DEVIATION REQUEST (Attach diagrams, figures, and other documentation to clarify request)

A deviation from the standards of or in Section **2.3.2** of the Engineering Criteria Manual (ECM) is requested.

HAVEN FOREST SCHOOL
5490 BURGESS ROAD, EL PASO COUNTY, CO

Figure 22 – Intersection Sight Distance at the Site Access on Burgess Road

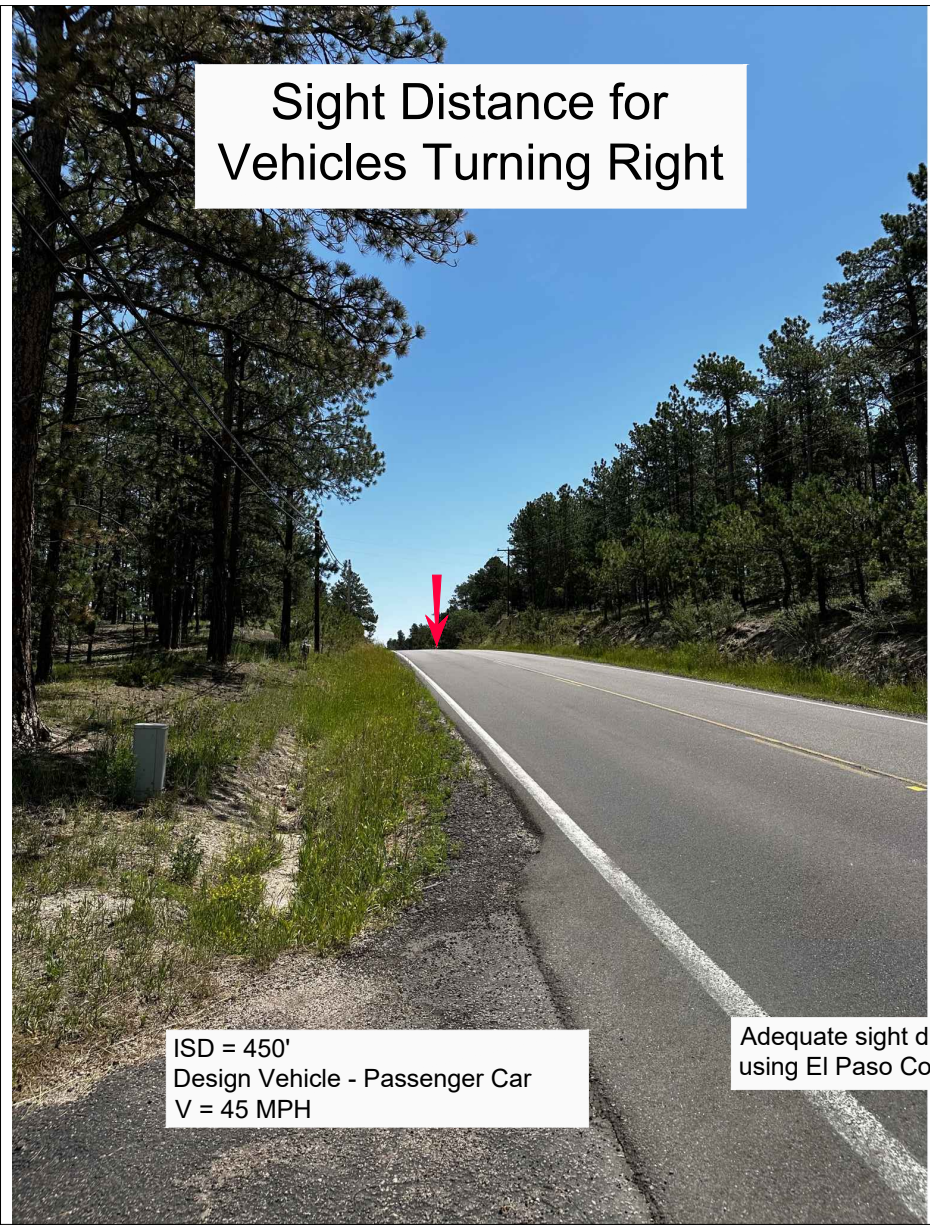
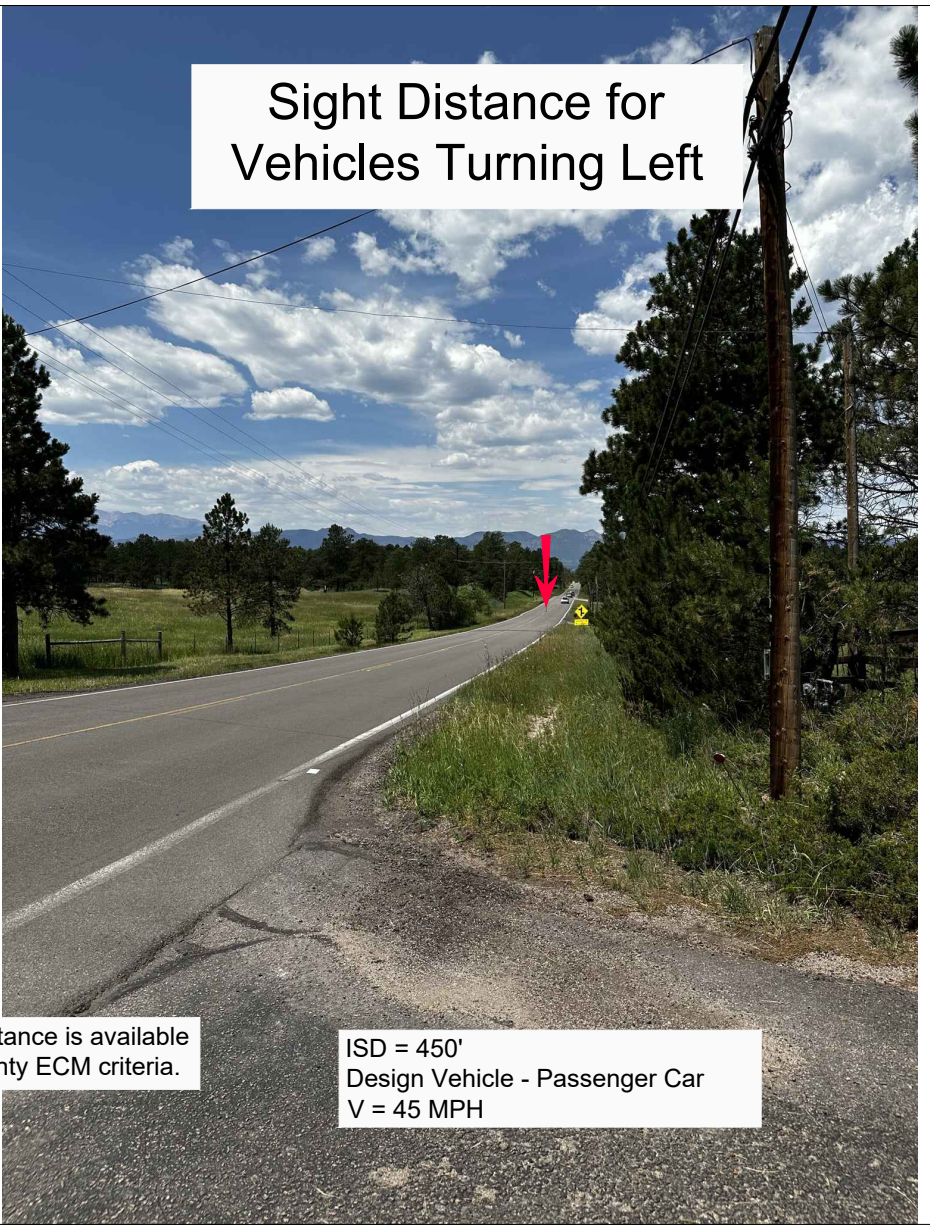
Line of Sight and entering sight distance from east and limitation for single unit trucks or school buses as detailed in TIS.
